Town and Country Planning Act 1990 (As amended)
Town and Country Planning (General Permitted development) Order 2015 Schedule 2 Part 1
Class A
Application for Prior Notification for a householder extension

Development Notification under extended permitted development rights for extending 4.135m from the original rear wall of the dwelling house. 2.7m high with an eaves height of 2.35m

Location 6 Onslow Drive Ferring

PROPOSED FLOOR PLAN

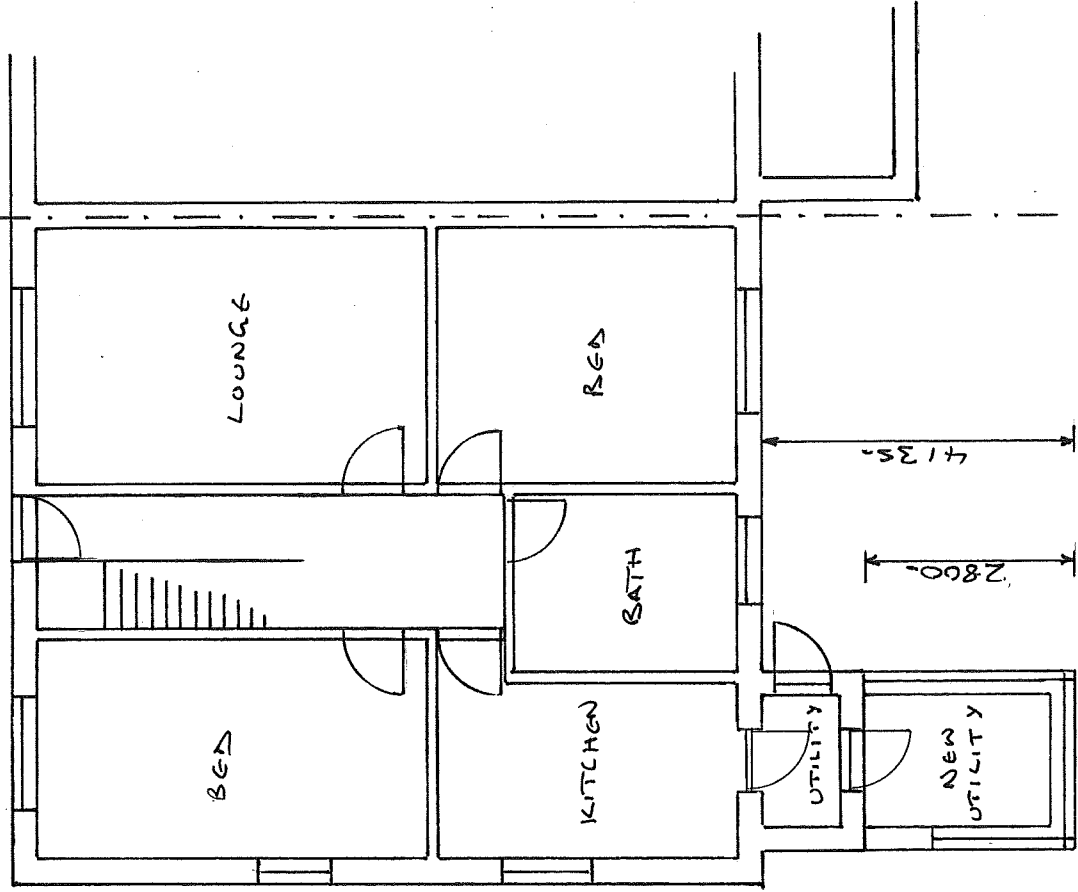
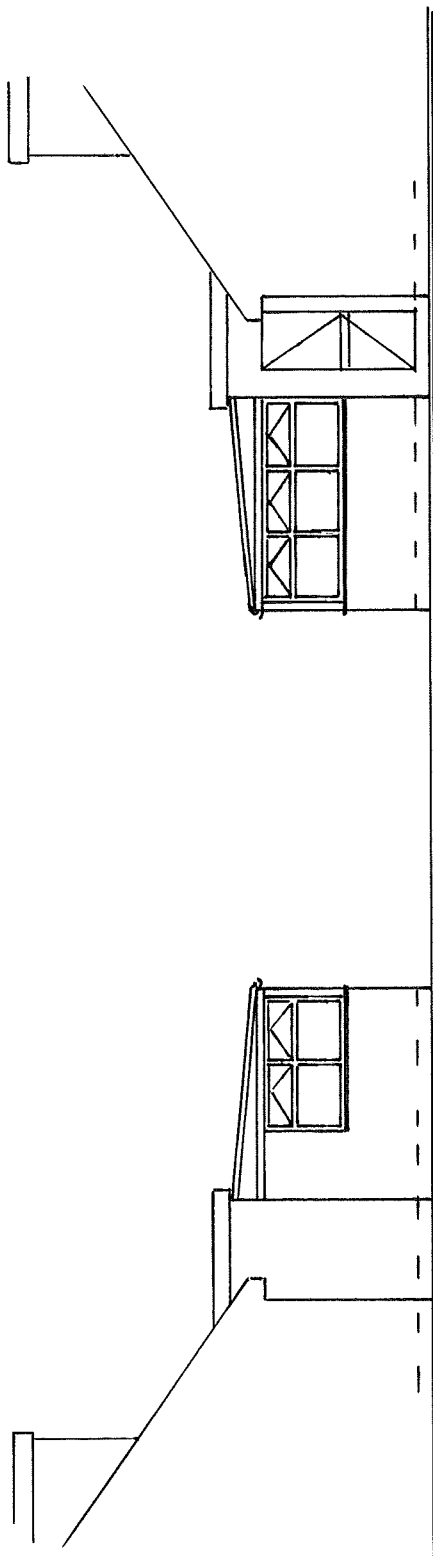
Please confirm what the description should read. The plans show utility extension. The description states a conservatory. Please specify.
